**Addendum to the EIAR - Downward Tunnel Realignment:  
St Stephen's Green Station to Charlemont Station**

06/03/24

- ML1-JAI-RTA-ROUT\_XX-DR-Y-01027 (Sheet 1 of 2): Tunnel Alignment Saint Stephens Green – Charlemont – RO Application Alignment.
- ML1-JAI-RTA-ROUT\_XX-DR-Y-01027 (Sheet 2 of 2): Tunnel Alignment Saint Stephens Green – Charlemont – RO Application vs Deeper Vertical Alignment Option.
- ML1-JAI-RTA-ROUT\_XX-DR-Y-00601: Underground Pumping Station Method Statement

Sheet 01 of 02

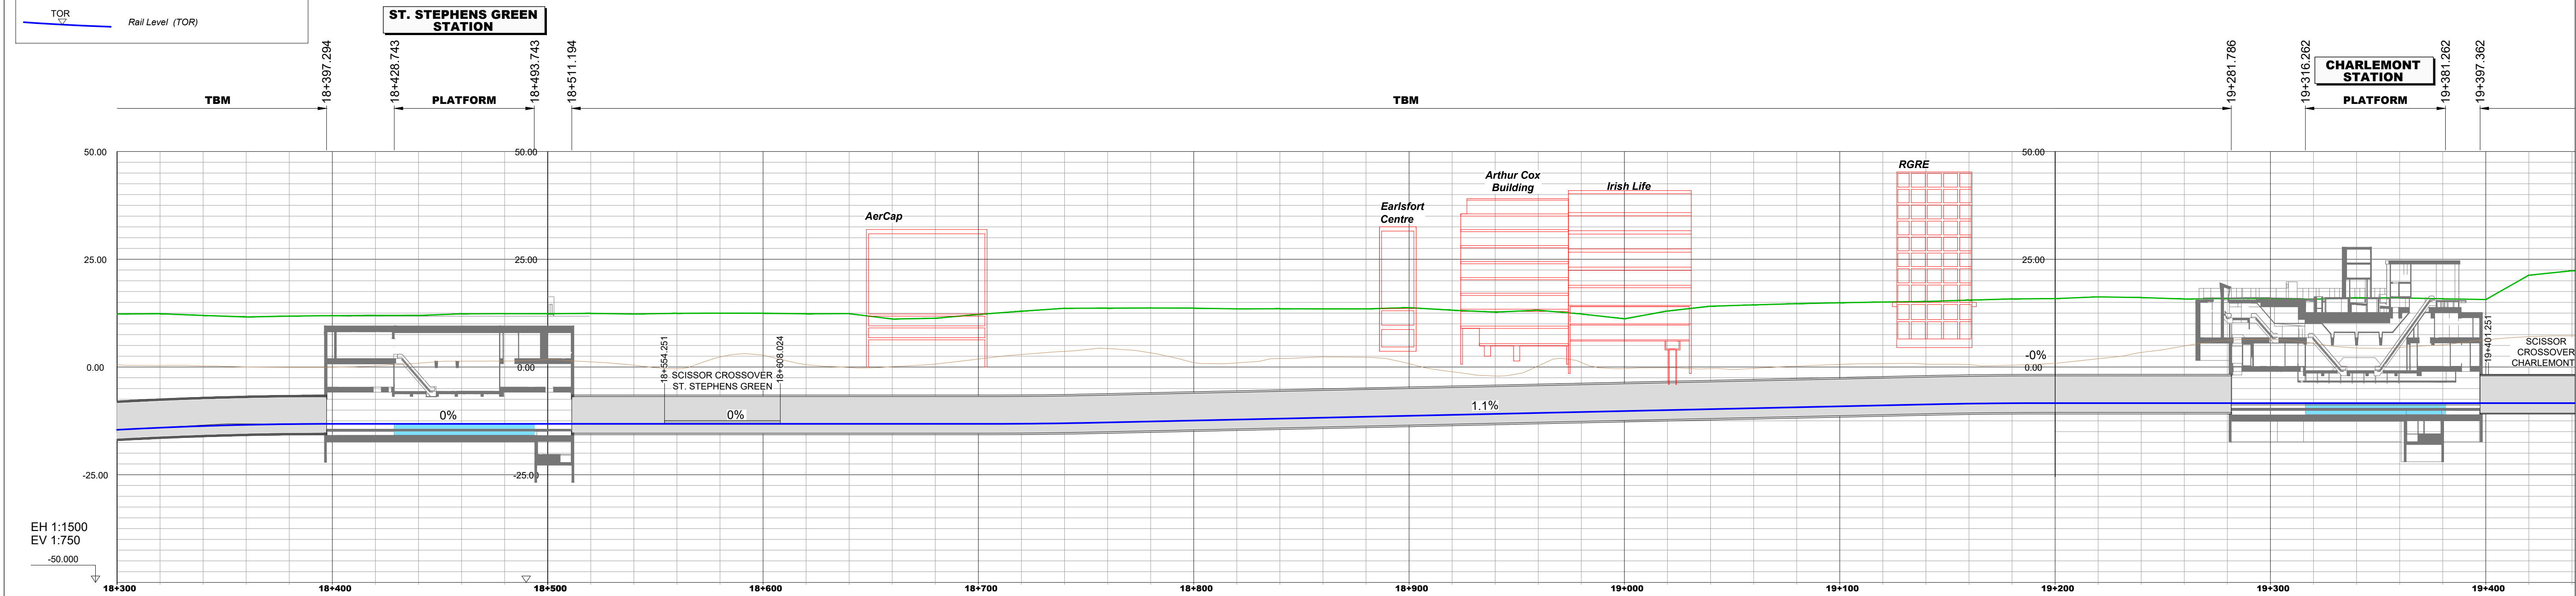
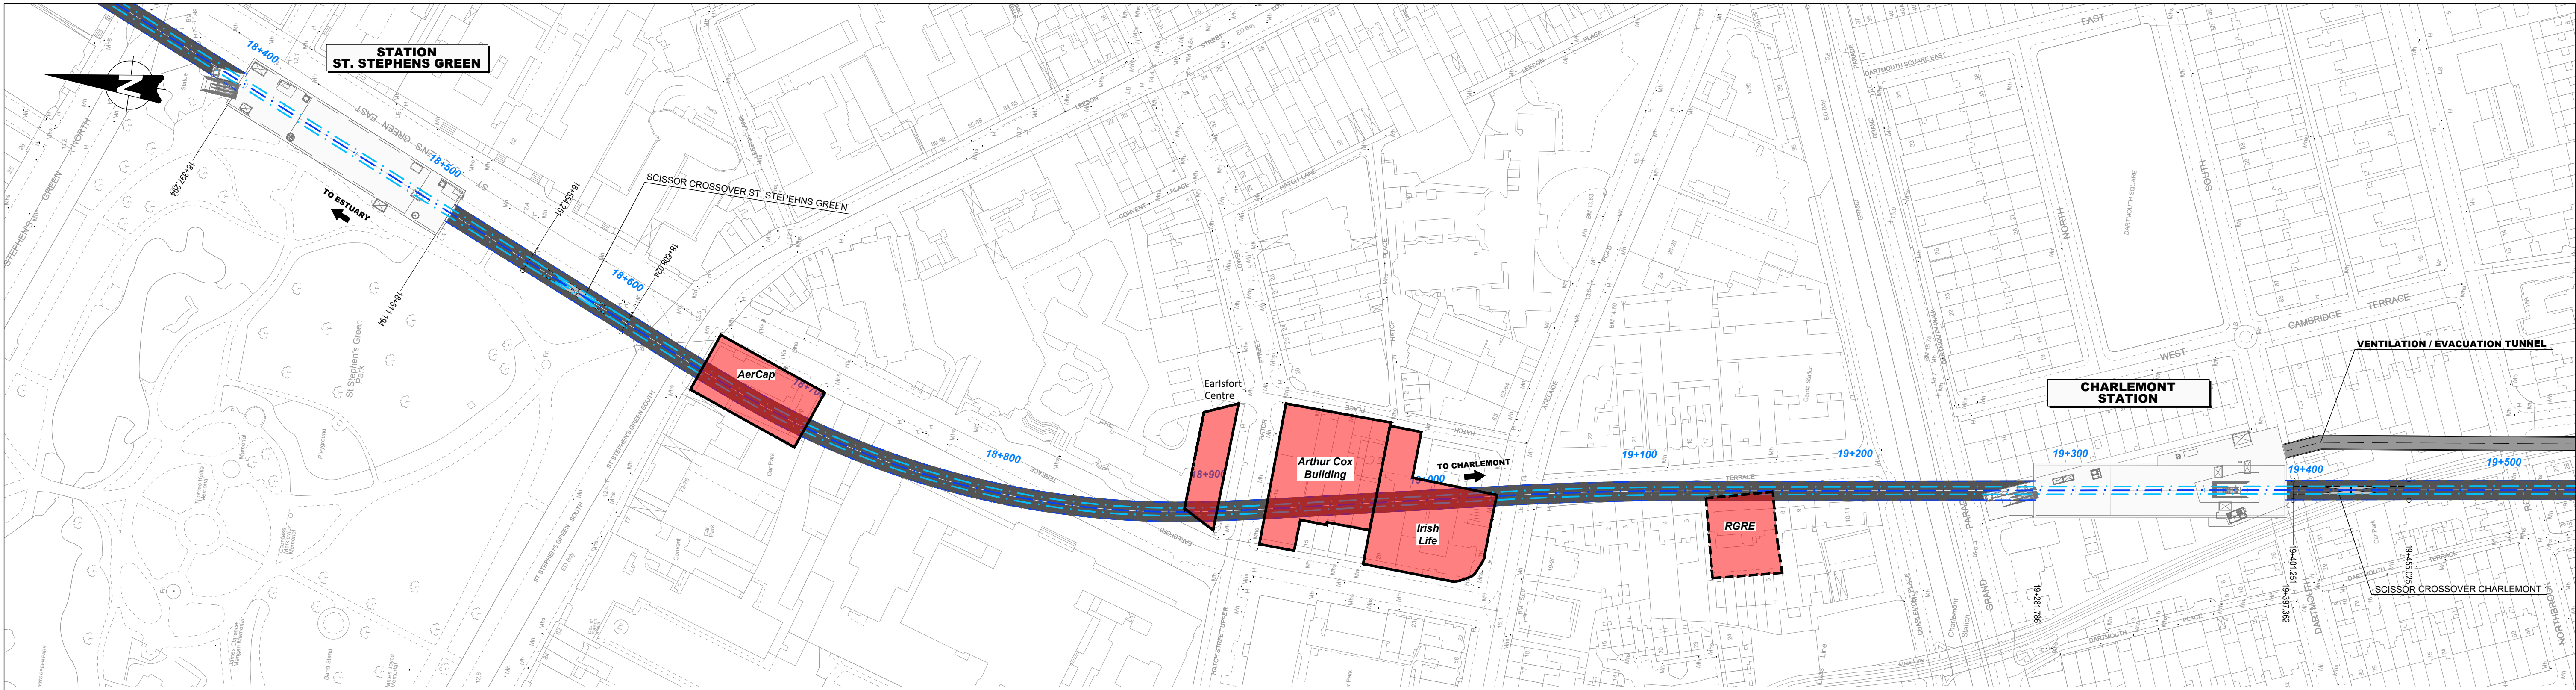
In order to ensure that there is no direct impact on these properties and to minimise any potential indirect impacts it is proposed to lower the tunnel a further 5m deeper along the tunnel at Ch18+940 (Below the junction of Hatch Street and Earlsfort Terrace). This will mean that the tunnel will be at a maximum of 5m deeper at the location identified above with the differential in depth decreasing as the alignment ties back into St Stephen's Green Station to the north and Charlemont Station to the south.

The vertical alignment has been reviewed to provide 5m deeper clearance below the ground anchors at the Irish Life building (Ch19+000). The horizontal alignment between St Stephen's Green and Charlemont Station (Ch18+540 and Ch19+300) is unchanged from the Proposed RO Works.

From the end of the clothoid at the entrance to the 400m curve in plan, the alignment descends with a gradient of 1.2% and then ascends with a gradient of 3% to link up with the Charlemont Station.

There is a low point at Ch18+958 with an elevation of -16.15 m. From this low point of the layout, a drainage system is designed to carry the water to the sump pump located at Ch18+919, under Hatch Street Upper, to minimize potential construction settlement and noise impacts on properties. The drainage slope required to locate the sump pump at this point is achieved by adjusting/deepening the drain profile under the tracks inside this short section of the tunnel.
